Subject: FW: Land At Rear Of Cedar End Eastergate Lane Eastergate PO20 3SJ - BN/65/22/PL

Proposed Site Plan
1:200

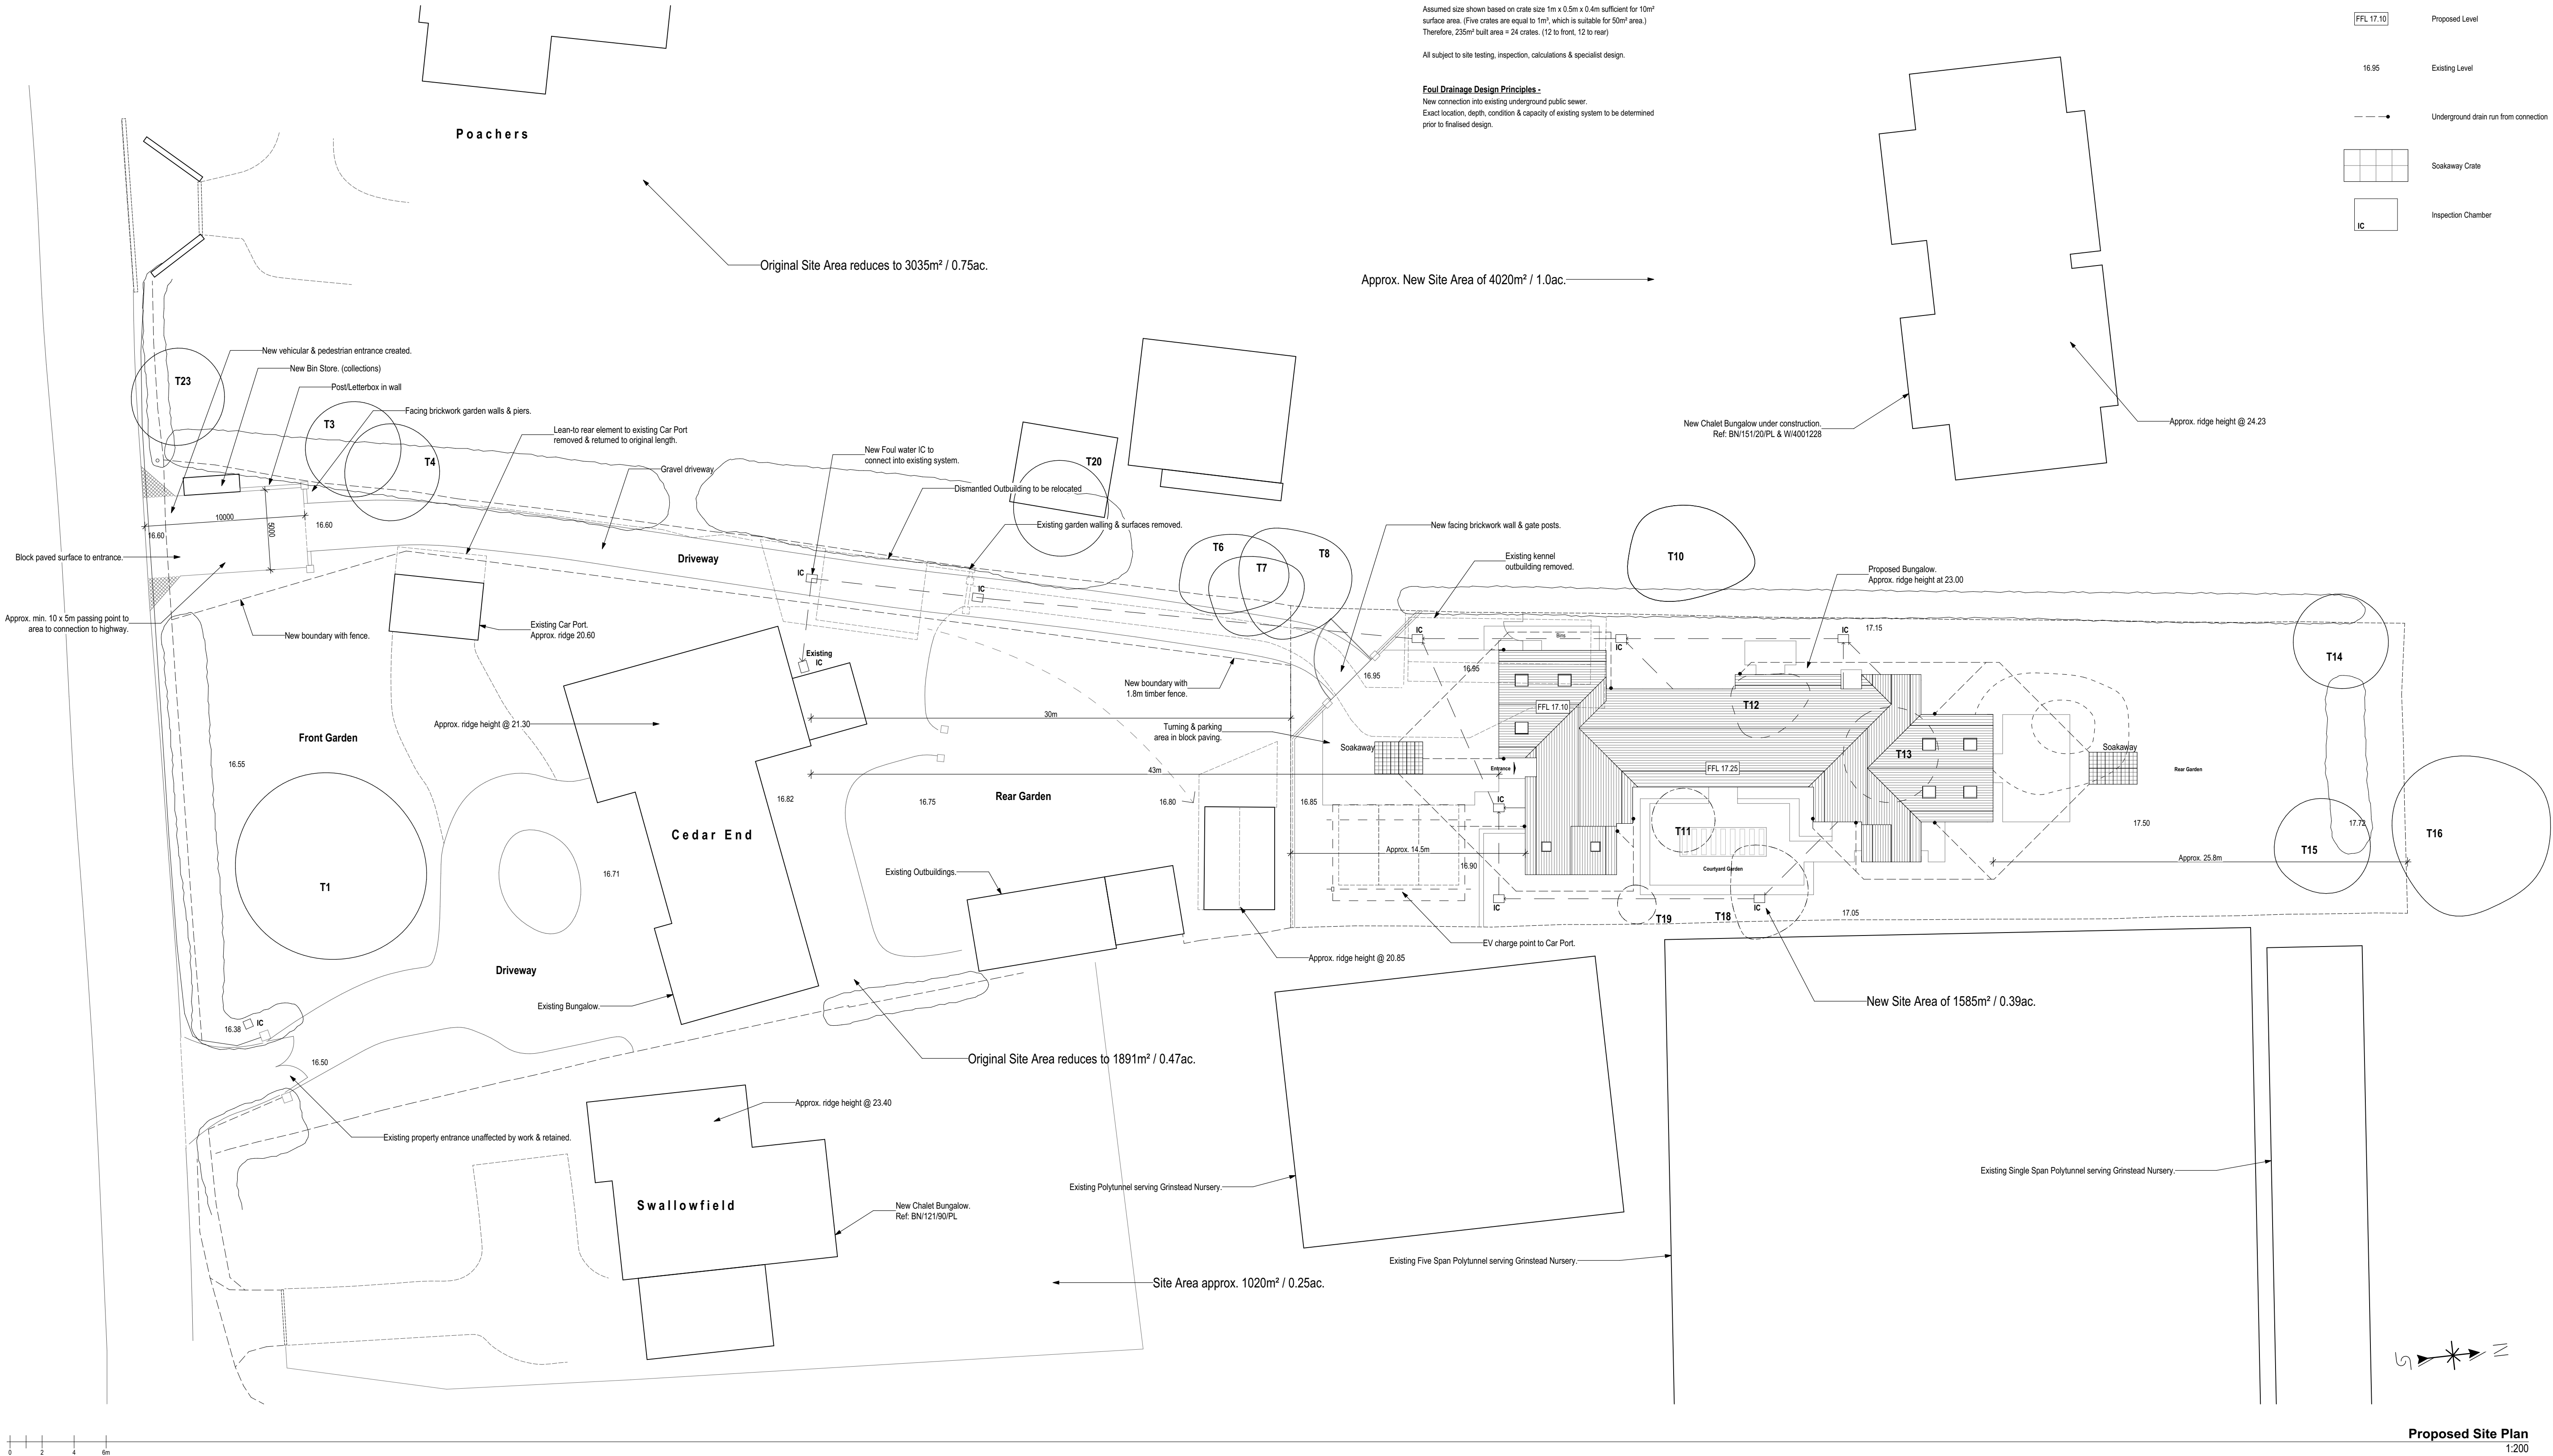
The Parish Council Committee also mention concern about the access and egress to the site, although it is noted that there are no concerns from the LA Highways Dept. The LA Highways response dated 29th June mentions a lack of dimensions being noted, however, our Site Plan (0207) has the minimum dimensions they request already shown. I have attached it here to assist your checking.

Fire Authority Compliance

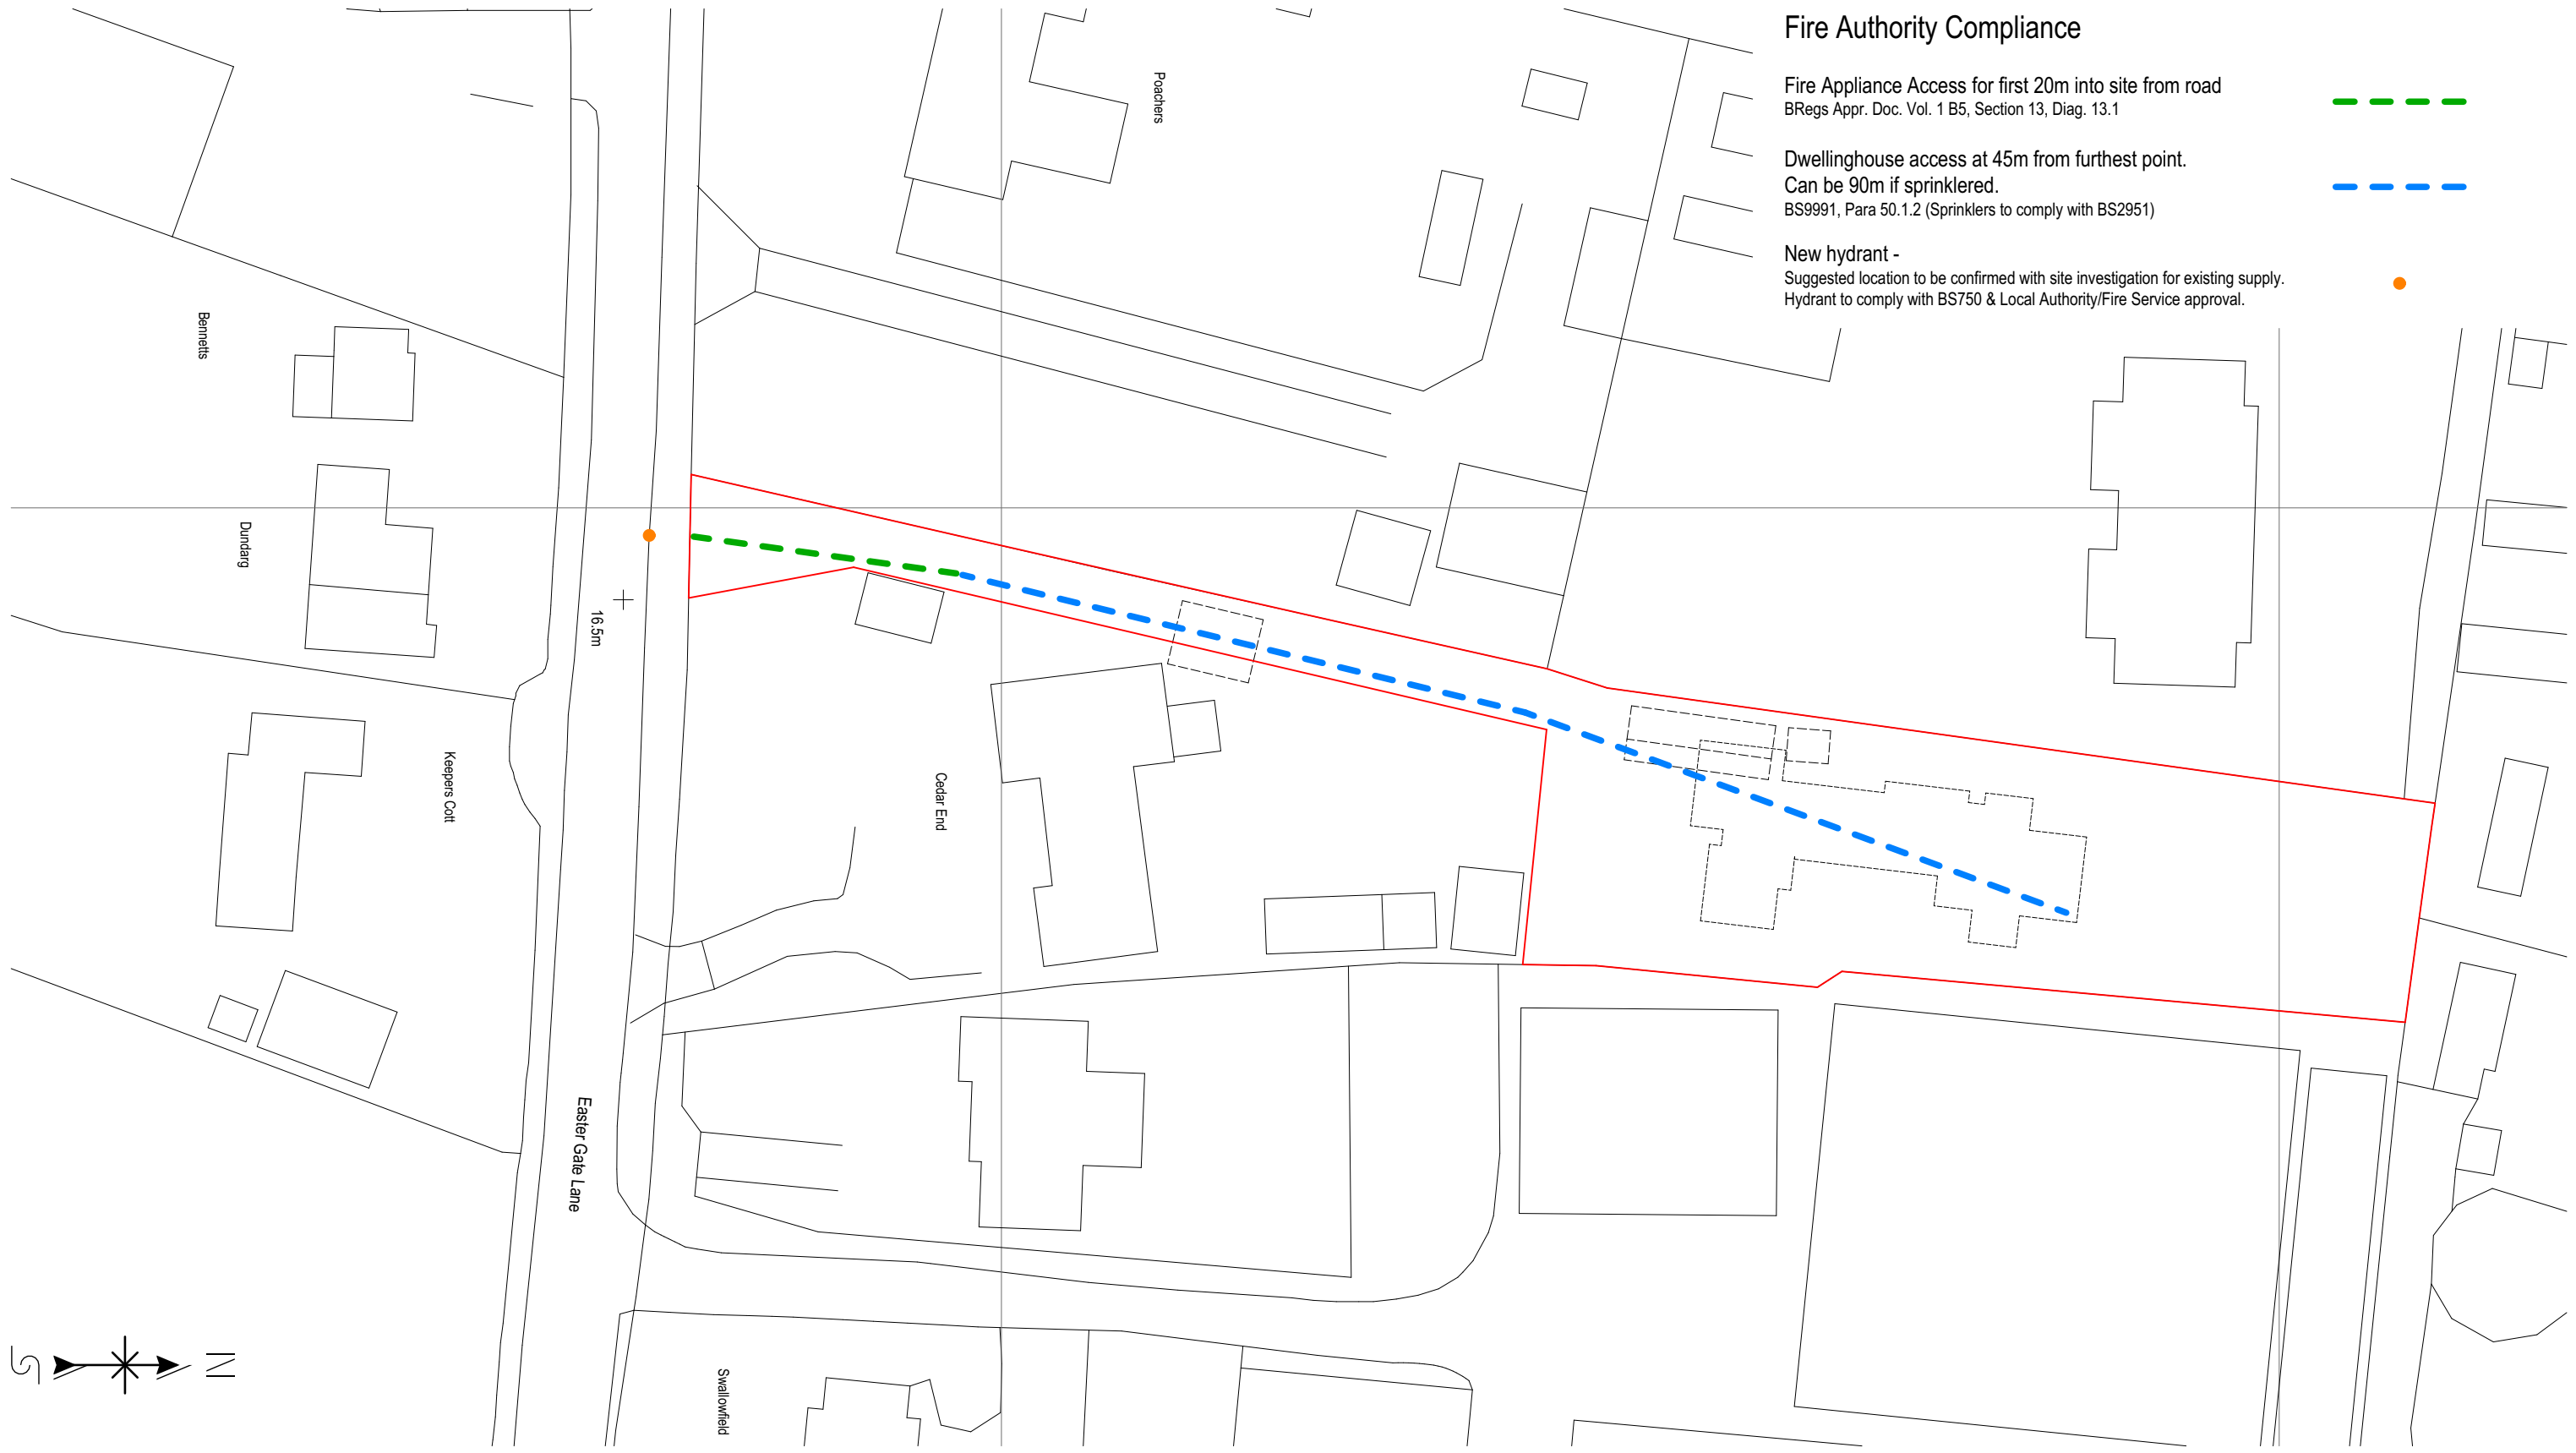
I have viewed the plan attached showing the location of an additional fire hydrant and satisfies West Sussex Fire & Rescue Services requirements. From the information on the plan it is indicating this property will be fully sprinklered to BS9251 standard, if this is the case the access to the property will be considered acceptable, the sprinkler system will give additional time for the attending fire crews to break out a rig additional firefighting equipment to be capable of reaching a fire incident in the property. A fire appliance only carries 175 metres of flat wall hoses that would be needed to attend a fire at this property. So providing the property is fully sprinklered and a fire appliance can gain access to within 90m of the property it will be considered acceptable.

We have seen the representation received by Mr Stocks (Water & Access Manager – Protection for West Sussex Fire & Rescue Service). Attached is drawing 0213 which addresses and resolves Mr Stocks' concerns. Please could you upload the drawing to the website.

- Fire Authority / Water & Access
New hydrant is now understood to be required & suggested location shown on the attached drawing.
I would confirm the suggestion of a condition to ensure this aspect is entirely satisfactory.
Building Regulations Firefighting Access compliance also shown on the attached drawing.
